**Engineering and Technology Precinct Development
The University of Sydney, Darlington Campus (SSD 8636) - Notice of Exhibition**

Thank you for your letter dated 16 April 2018, requesting Transport for NSW (TfNSW) review and comment on the above.

USYD ENGINEERING AND TECHNOLOGY

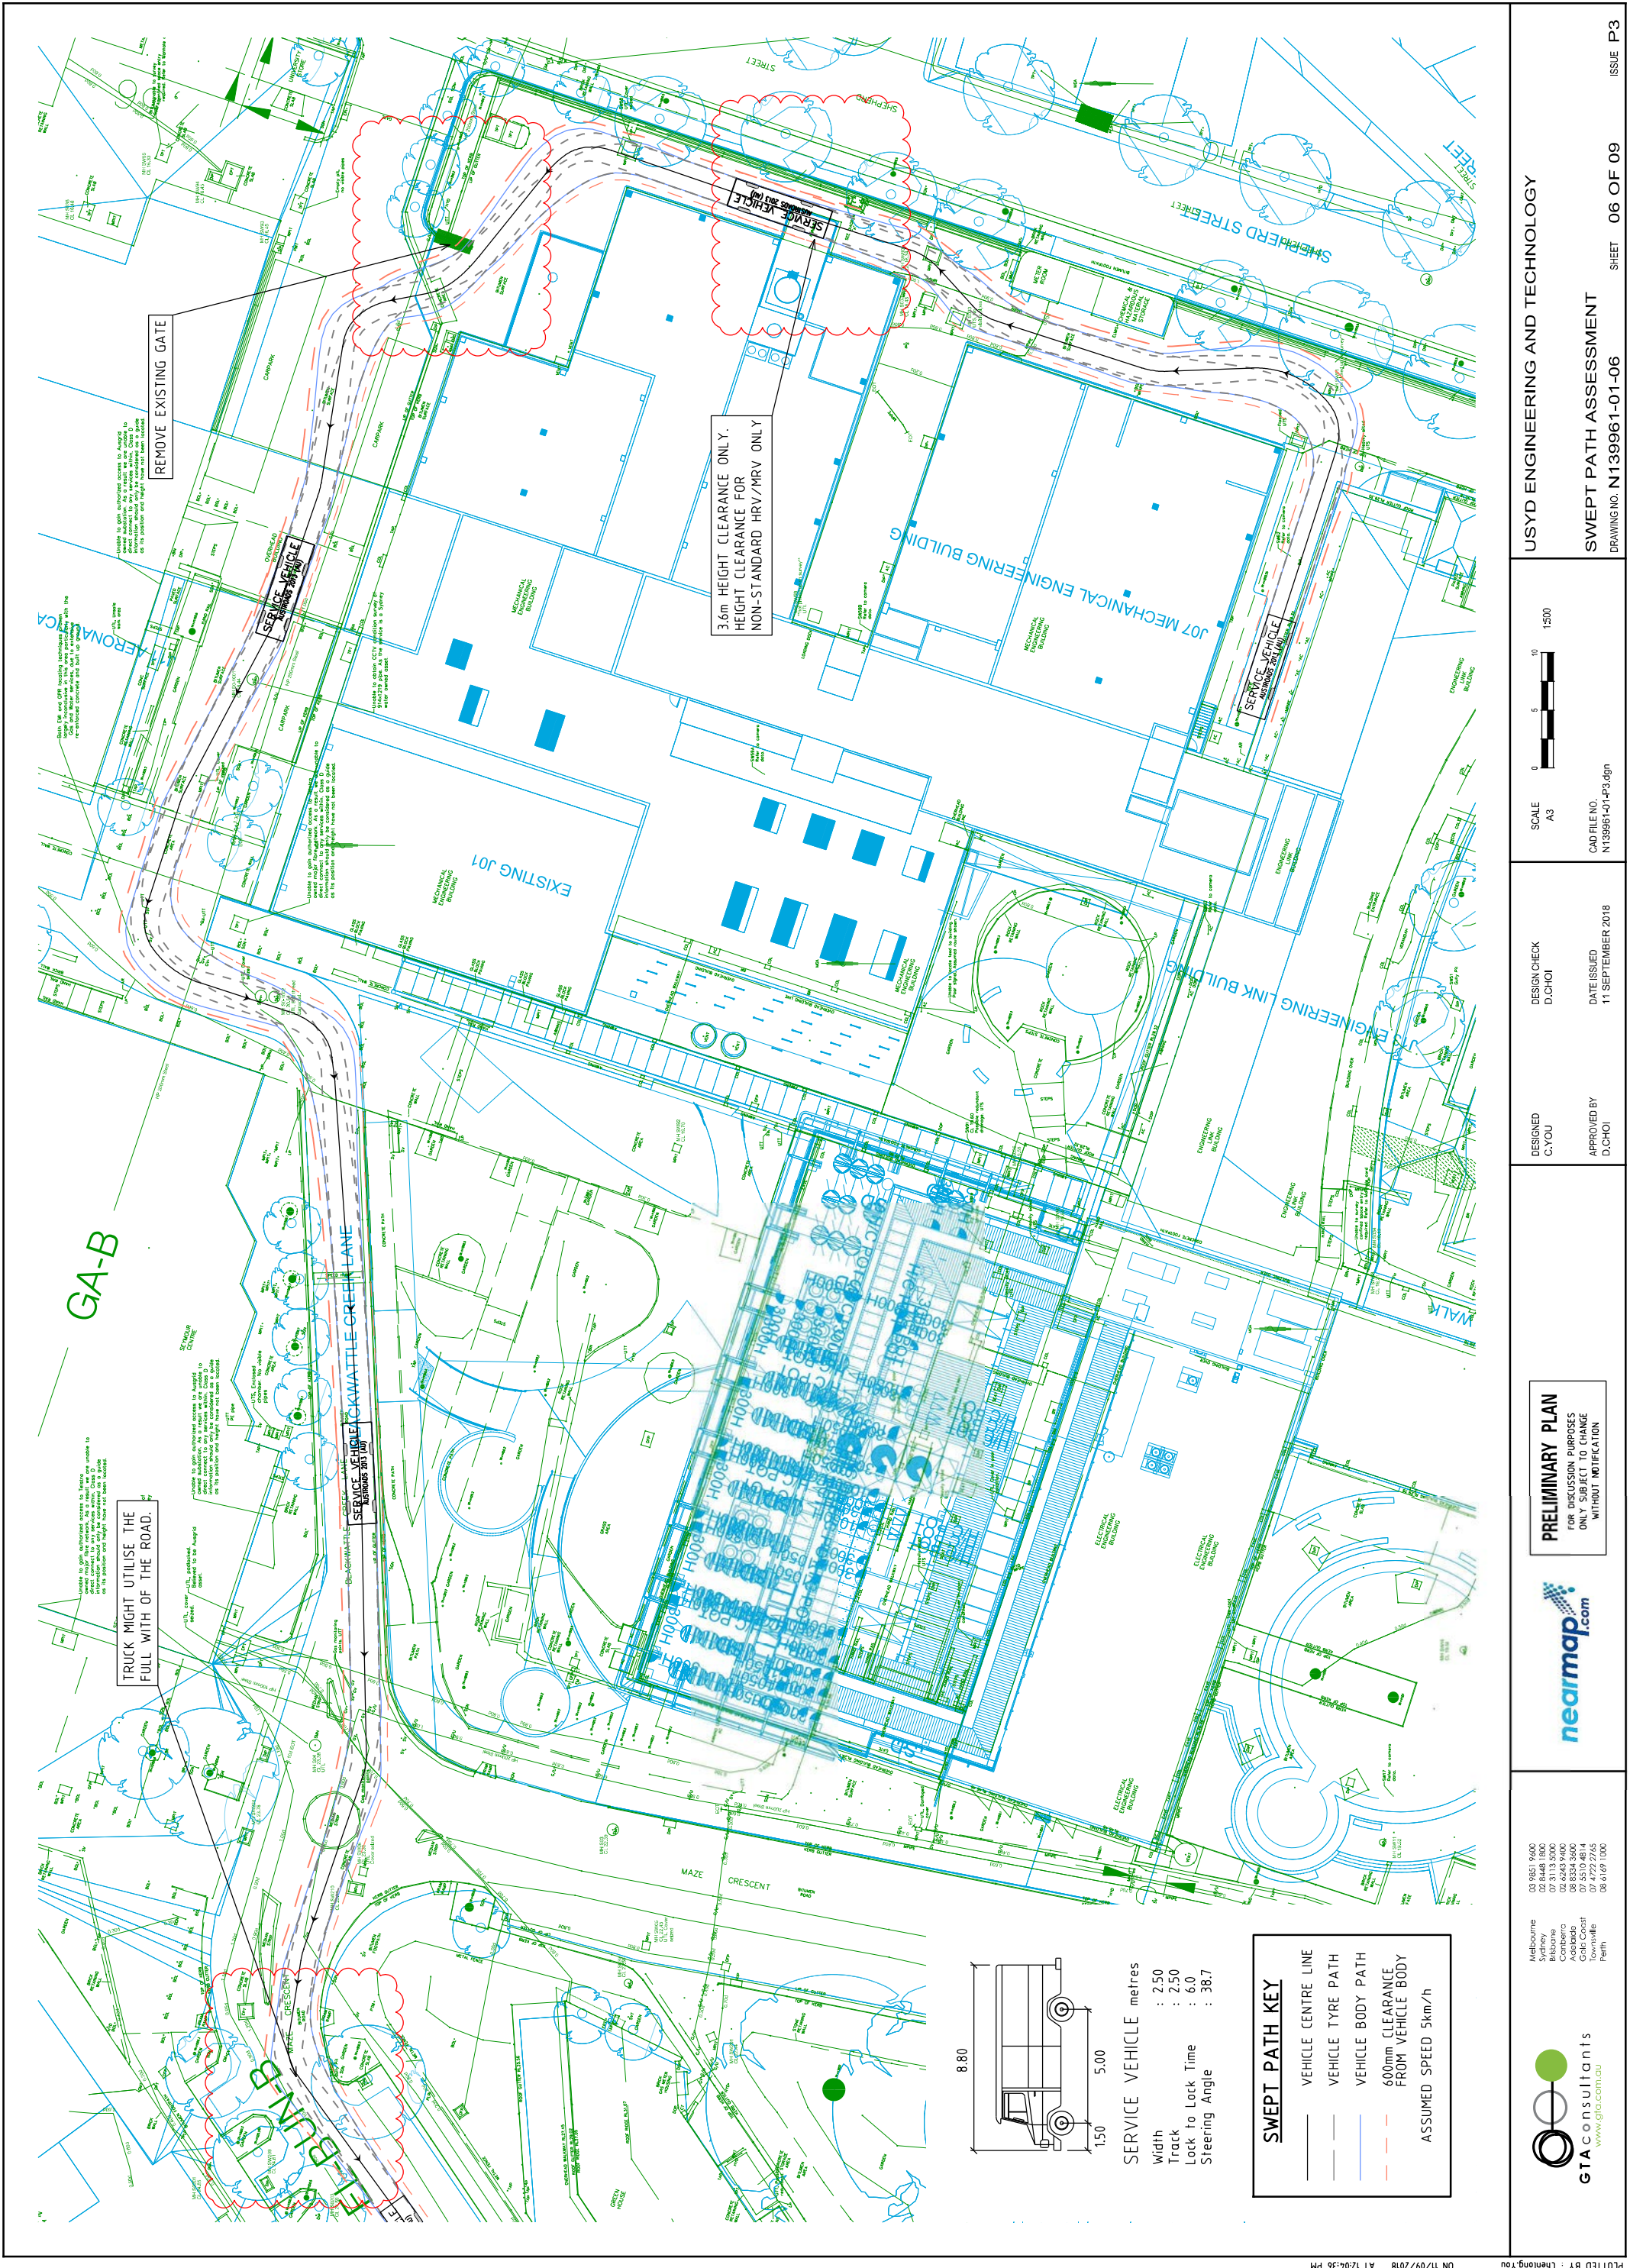
- The Traffic and Accessibility Assessment Report prepared to support the development application includes swept path analysis that shows a vehicle reversing into the loading dock. Proposed measures (other than signage) to manage the conflicts between reversing vehicles and pedestrians are not provided;
- The Swept path analysis needs to show servicing and loading vehicles accessing the proposed development from Shepherd Street; and
- No analysis has been undertaken to demonstrate the management of the loading dock, in particular the adequacy of loading dock and servicing arrangements to accommodate the future demand, ensuring all servicing and loading occurs on-site.

- Further details on how conflicts with reversing vehicles and pedestrians will be managed. If this conflict can't be adequately managed, the design should be modified to eliminate the need for reversing vehicles;

- Swept path analysis for servicing and loading vehicles accessing the proposed development from Shepherd Street. If access from Shepherd Street is to be restricted, details on how vehicles will be prevented from accessing the proposed development from Shepherd Street should be provided; and
- Loading bay management details including the adequacy of loading dock and servicing arrangements to accommodate the future demand and service vehicle movements during peak periods.
